From: Emma Avis 
Sent: 09 October 2020 15:01
To: Simon Davis <Simon.Davis@arun.gov.uk>
Subject: AL/64/20 Springfield Hook Lane Aldinbourne - Highways Re-consultation for tracking diagrams

I've just been reviewing the revised site layout, drawing no: 1186/DP04 Rev 01. In general the LHA would raise no concerns and the previously proposed conditions should still stand (under AL/27/20). I have noticed though that the dedicated turning head has been lost somewhat in the design and now also accommodates visitor parking spaces. The applicant needs to provide some tracking of a refuse vehicle to demonstrate that a collection vehicle can turn fully on site and enter the highway in forward gear. Also that any parking arrangements will not hinder this movement.

SWEPT PATH ANALYSIS
LARGE REFUSE ENTERING/EXITING SITE

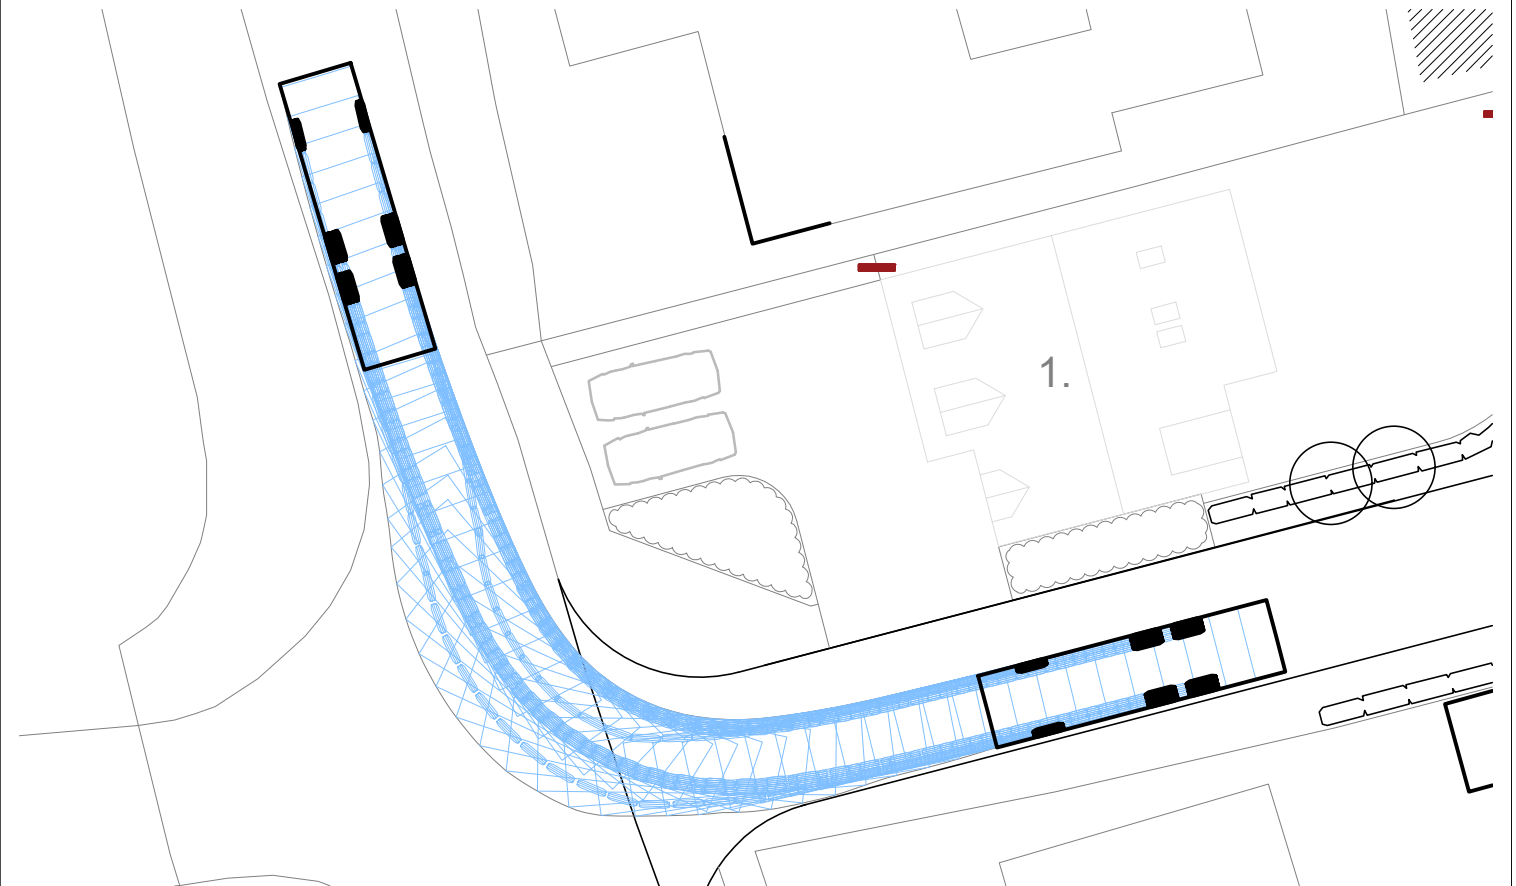
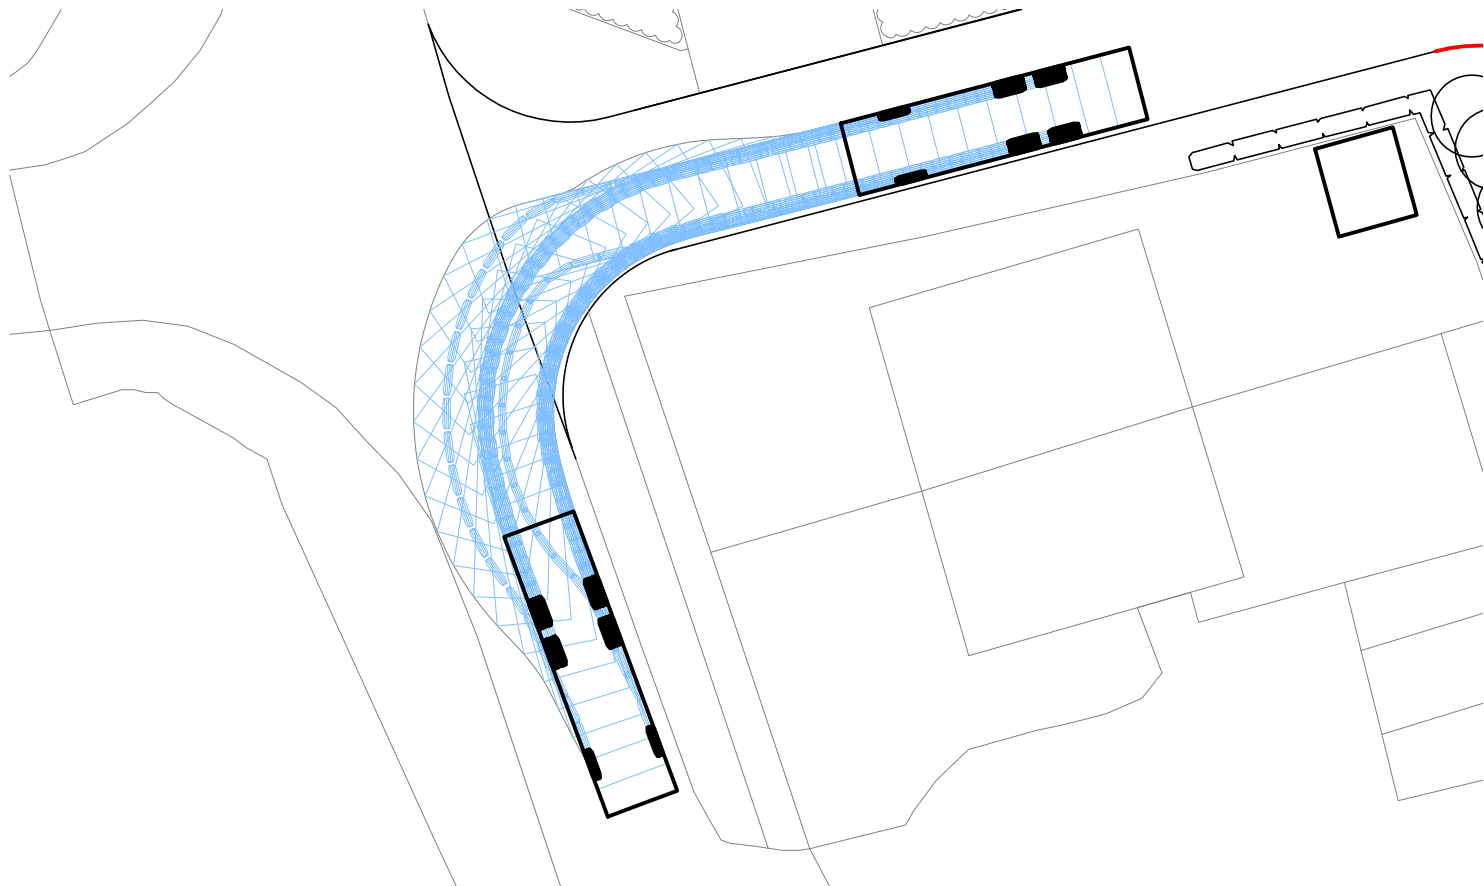
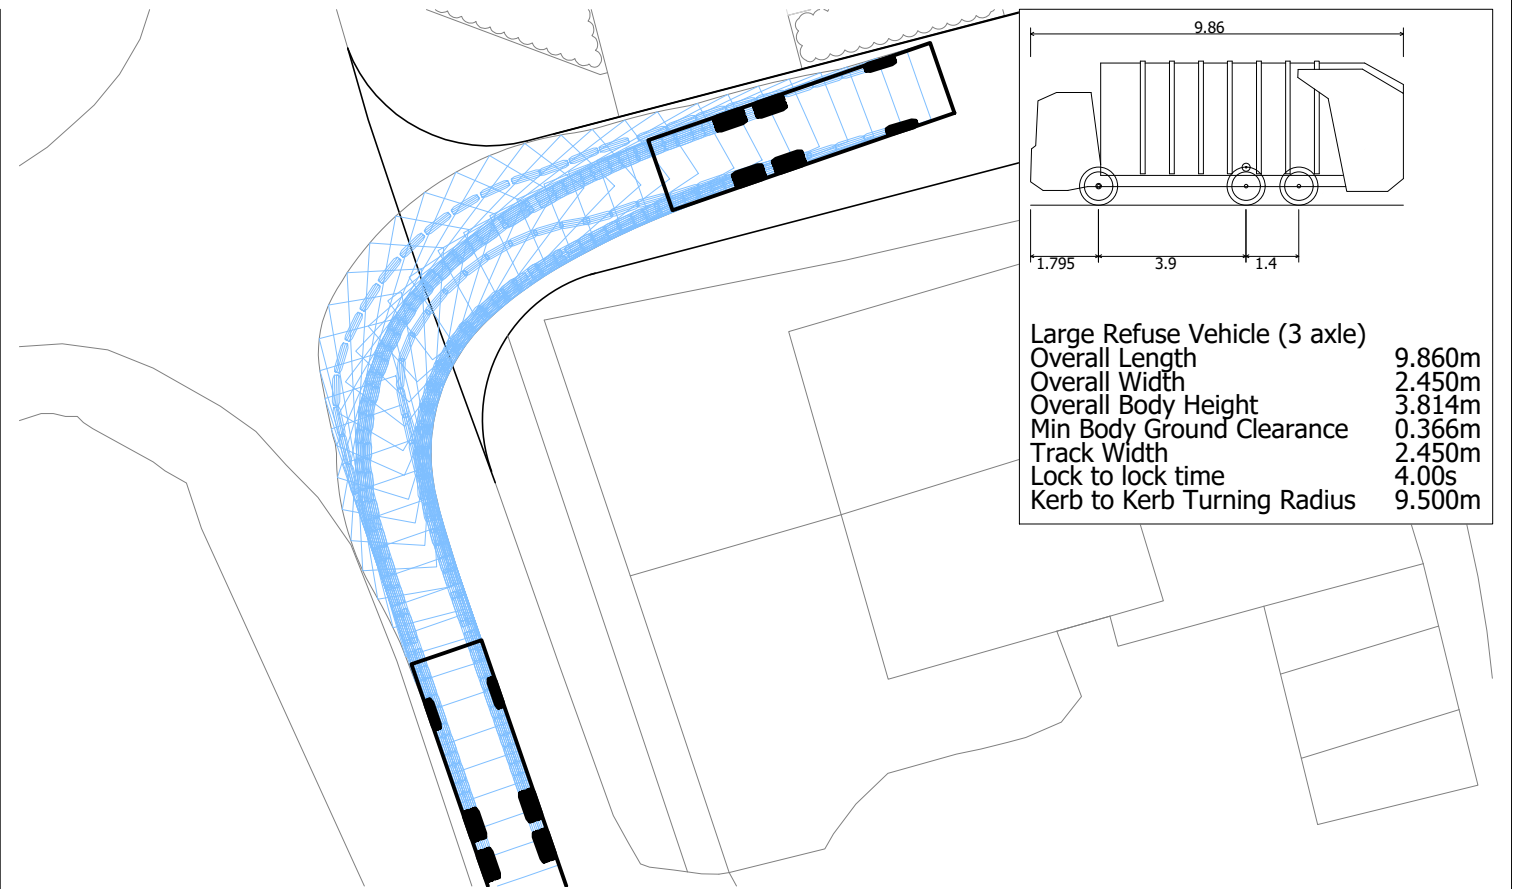
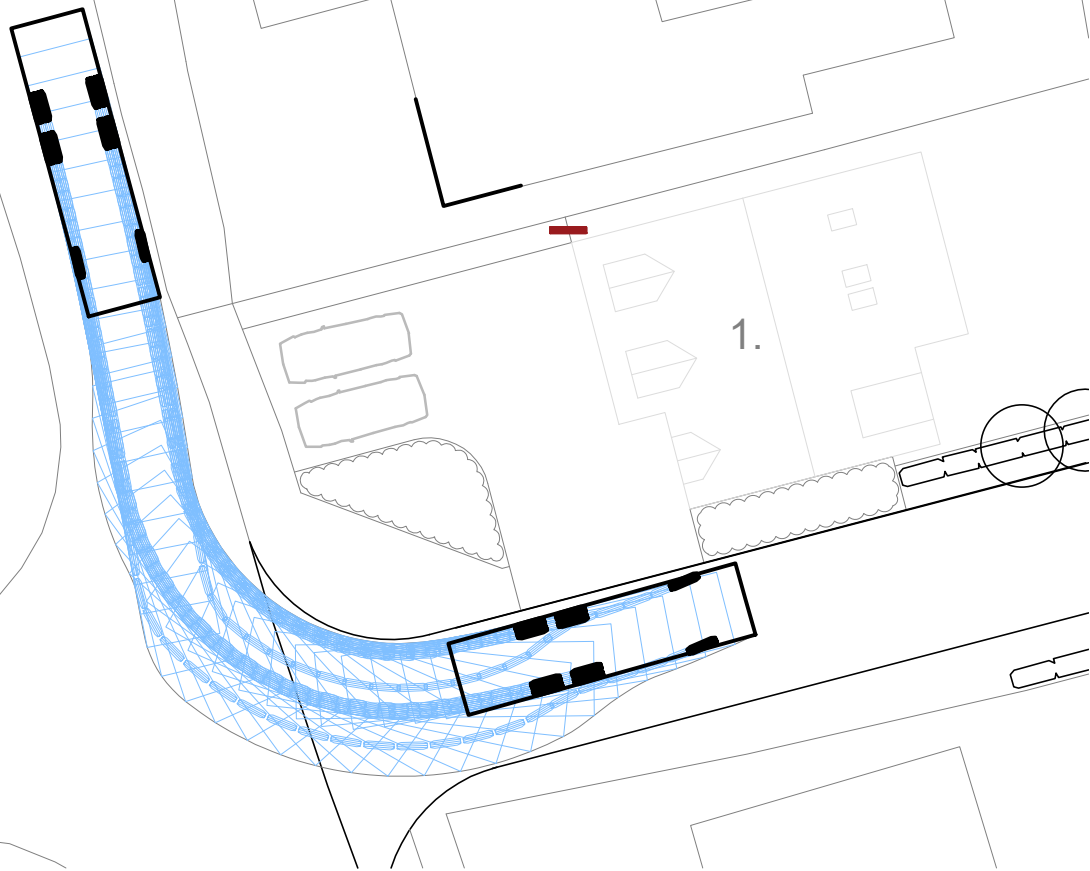
We have reviewed the supplied tracking drawings and would raise no concerns to these. It would be an idea to make sure all parking and turning areas are used for their intended use so a Parking & Turning Condition would be advised.

Condition - Vehicle parking and turning

No part of the development shall be first occupied until the vehicle parking and turning spaces have been constructed in accordance with the approved plan. These spaces shall thereafter be retained for their designated use.
